**Consultation Response from KC,
Highways Development Management**
2020/92307 Penistone Road/, Rowley Lane, Fenay Bridge, Huddersfield, HD8 0JS
Outline application for erection of residential development
Date Responded:
15/12/2020

2020/92307 Penistone Road/Rowley Lane, Fenay Bridge.

Highway Development Management's (HDM) comments for the above application as follows:

Movement Diagram (NTS)

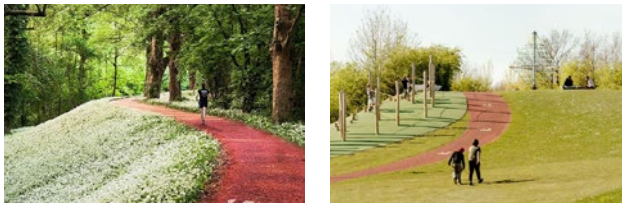
Cul-de-sac road layouts must be avoided to reduce the need to reverse an RCV. The concept layout consists mainly of cul-de-sacs and shared private drives which prevent connectivity and increase the need to reverse RCVs. Legislative changes coupled with housing growth will put pressure on the Council to utilise bigger, more efficient vehicles and the need to accommodate these safely, with minimal reversing is vital.
